# Consultee Comments for Planning Application 23/02758/FUL

Application Number: 23/02758/FUL

Proposal: Erection of 9 no. dwellingshouses together with associated access, infrastructure, parking and landscaping.

On Behalf Of: Coastal And Drainage Engineer

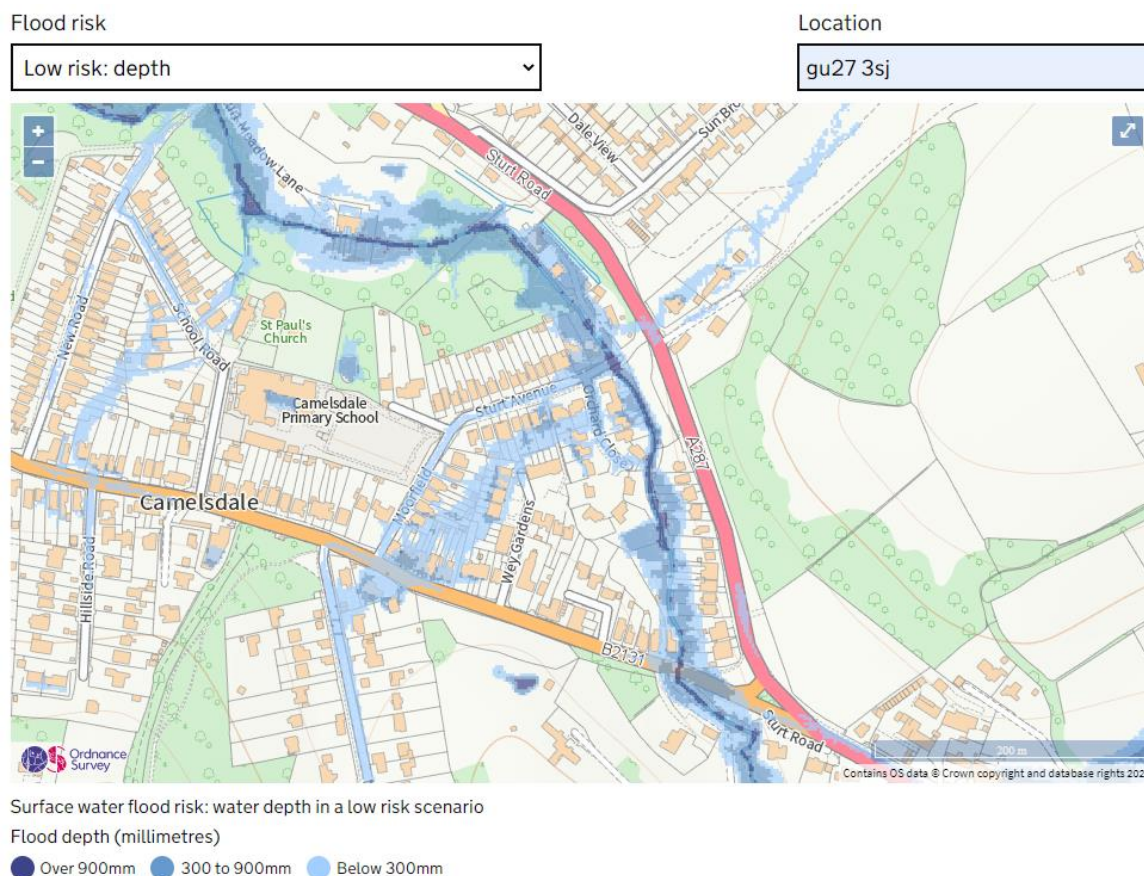
I also disagree with the following statement from section 4.2 of the Flood Risk Assessment and Drainage Strategy:

Following receipt of the Hydrogeology report, the groundwater has been shown to be at 0.8m to 1.3m across the site. This was recorded in November 2023 following a very wet period of weather over a number of months. The report states that it is anticipated that the levels shown would be close the maximum levels expected.

Regardless that the measurements quoted above were taken following a period of very wet weather; I would expect to see groundwater levels peaking much later in the wet winter months, (late January through to early March), plus given my knowledge of the site I suspect groundwater levels may be much closer to, or even at, the surface at those times.

Scale at A1 - 1:200
303383-SWH-XX-XX-DR-C-501 P07
 Project | Originator | Zone | Level | Type | Role | Number | Rev.

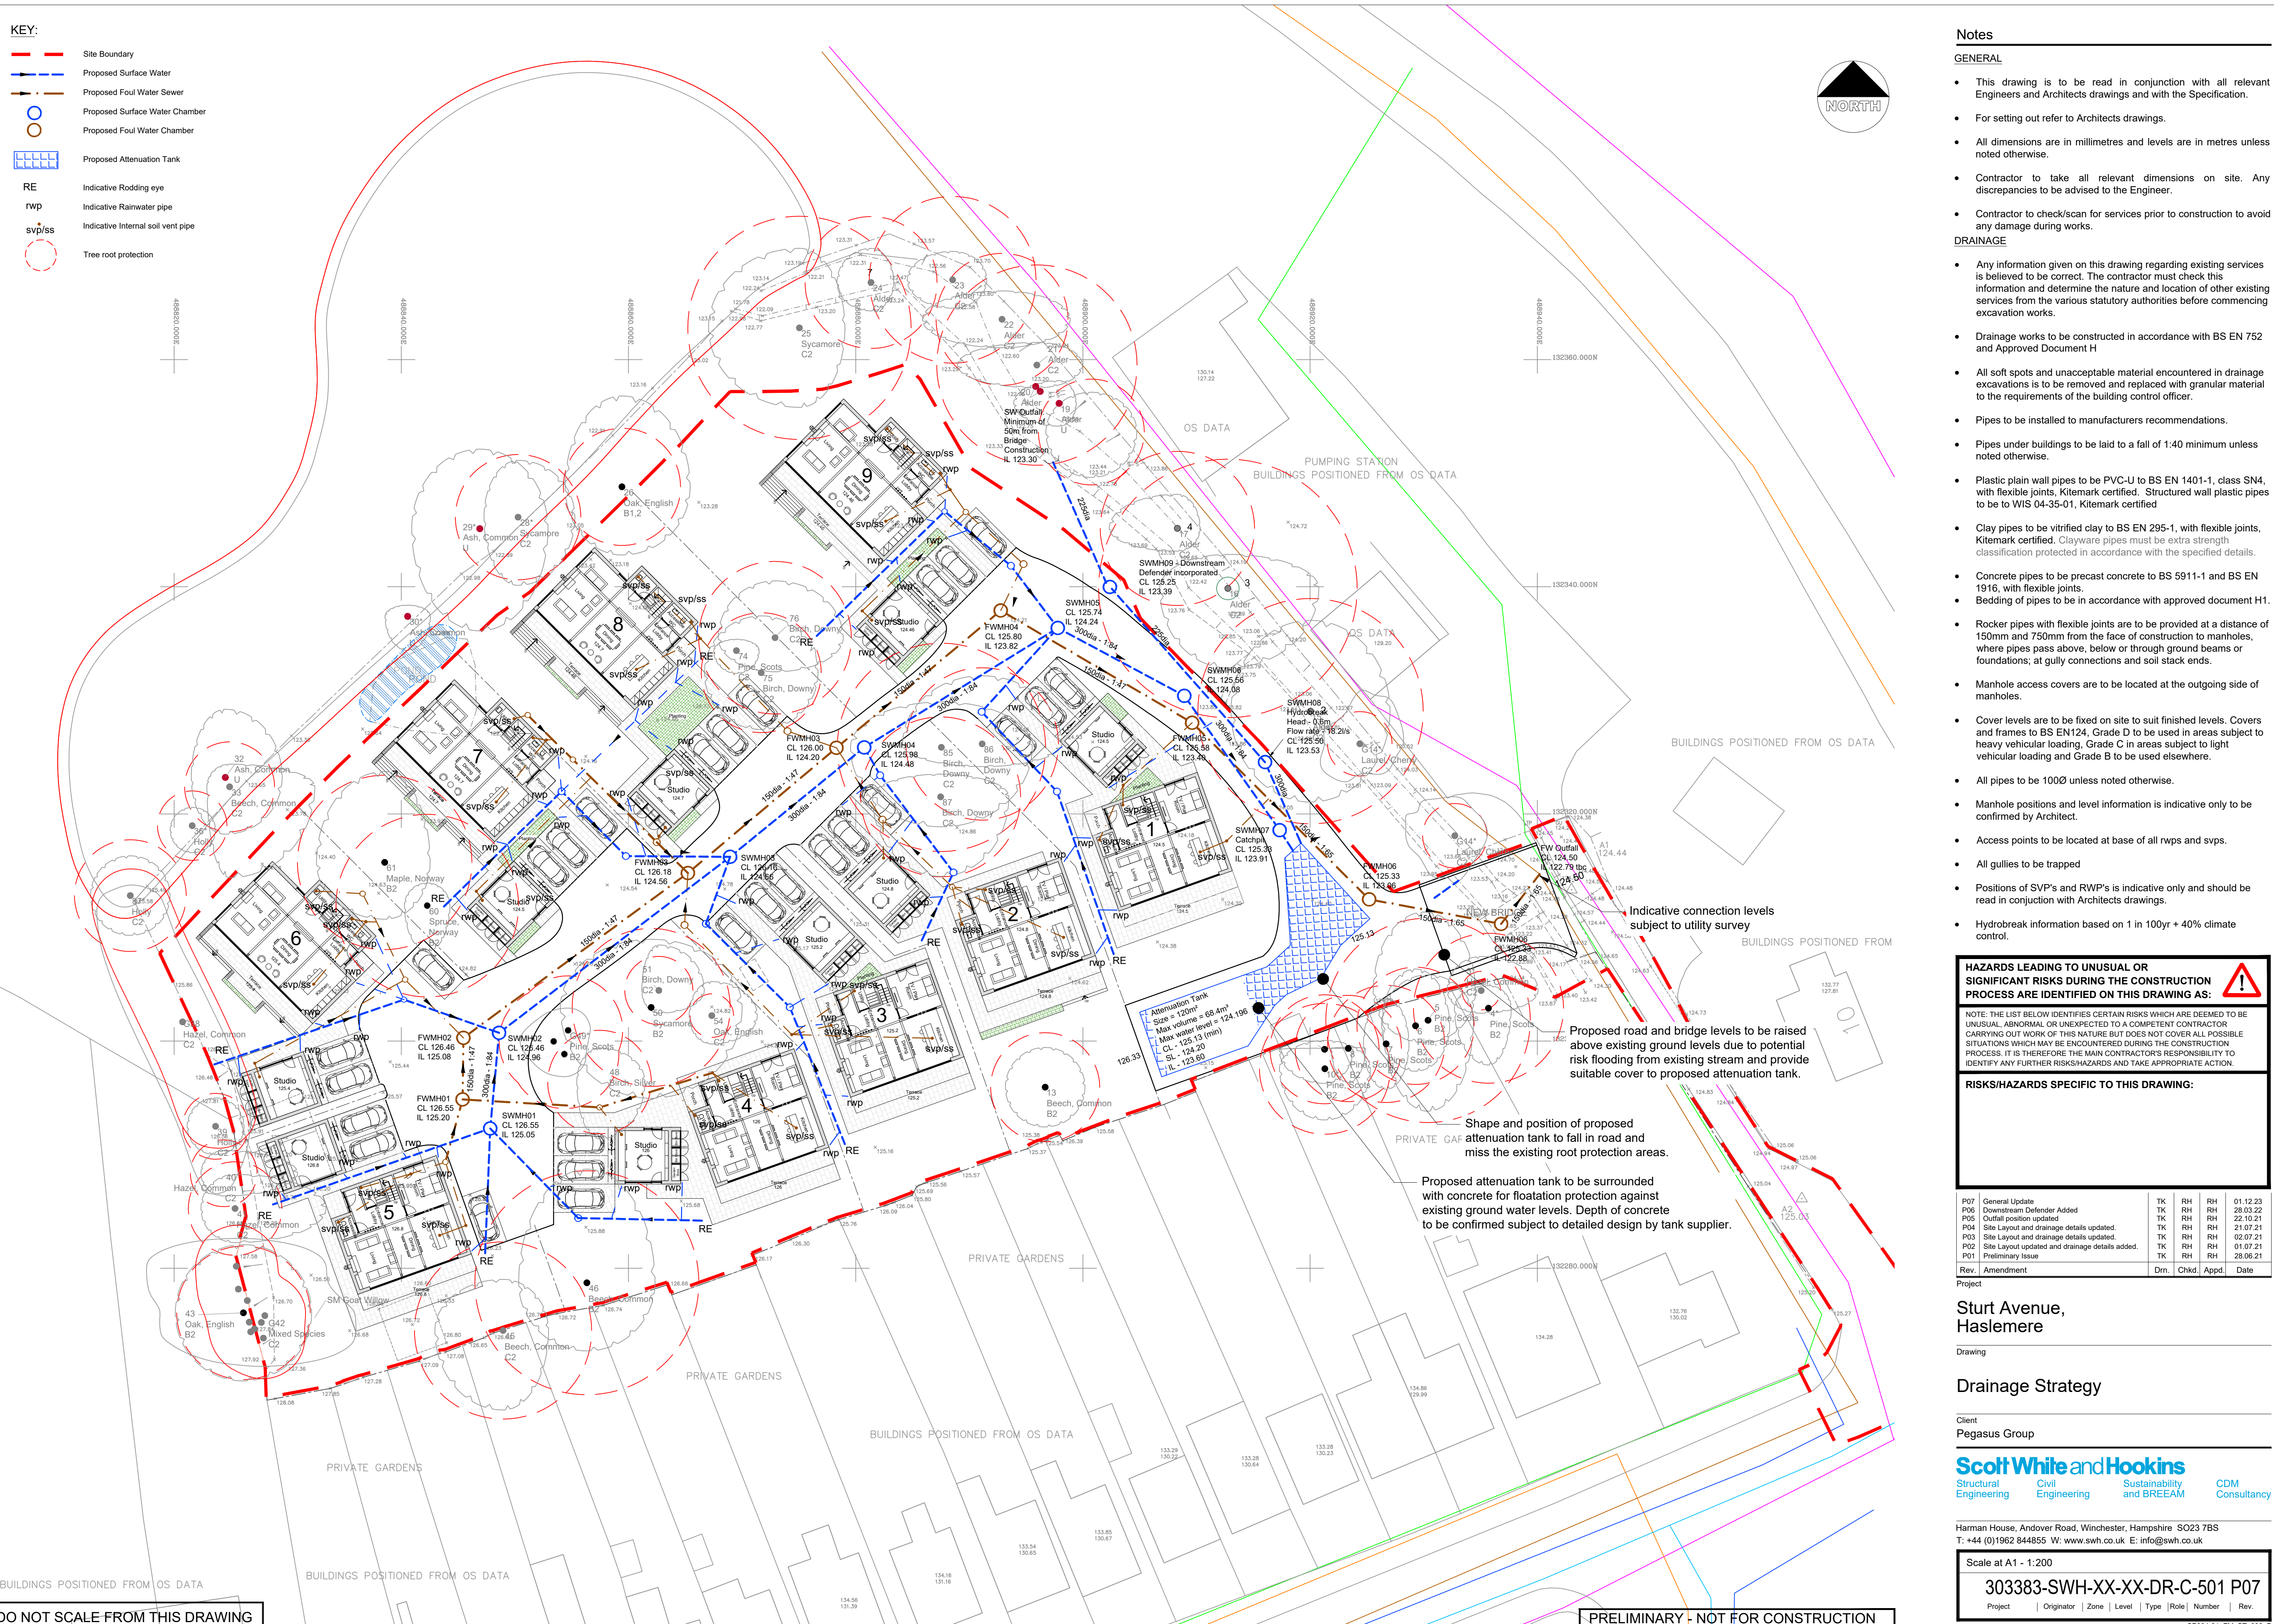
I also note the proposed reduction in the area of the existing on-site pond. The existing pond straddles the red-line boundary of the site, but the proposed site layout shows the entirety of the pond outside the red-line boundary. For a clear illustration of this point I refer you to the image at the top of page 19 (section 5.2.10) of the Flood Risk Assessment and Drainage Strategy document, where the grey outline of the existing pond can be seen extending beneath the proposed structure of plot 7.

Ponds offer surface water storage capacity and natural attenuation. Therefore, we would prefer that the ponds existing footprint is retained and that it is subjected to routine maintenance (in the form of de-siltation and the removal of excess vegetation) as part of these proposals.

As the surface water drainage from the site is ultimately to be discharged to the adjacent designated main river the applicant may need to obtain the appropriate permission from the Environment Agency, in parallel with planning permission. Additionally, the EA should be consulted about their satisfaction that the proposed layout does not prevent the future appropriate maintenance of the River Wey (again, clarification of where the land ownership and riparian responsibilities related to the land between the developments red line and the river will lie is needed). Concerningly, the SuDS discharge pipe and headwall also are located outside of the red line of the development.
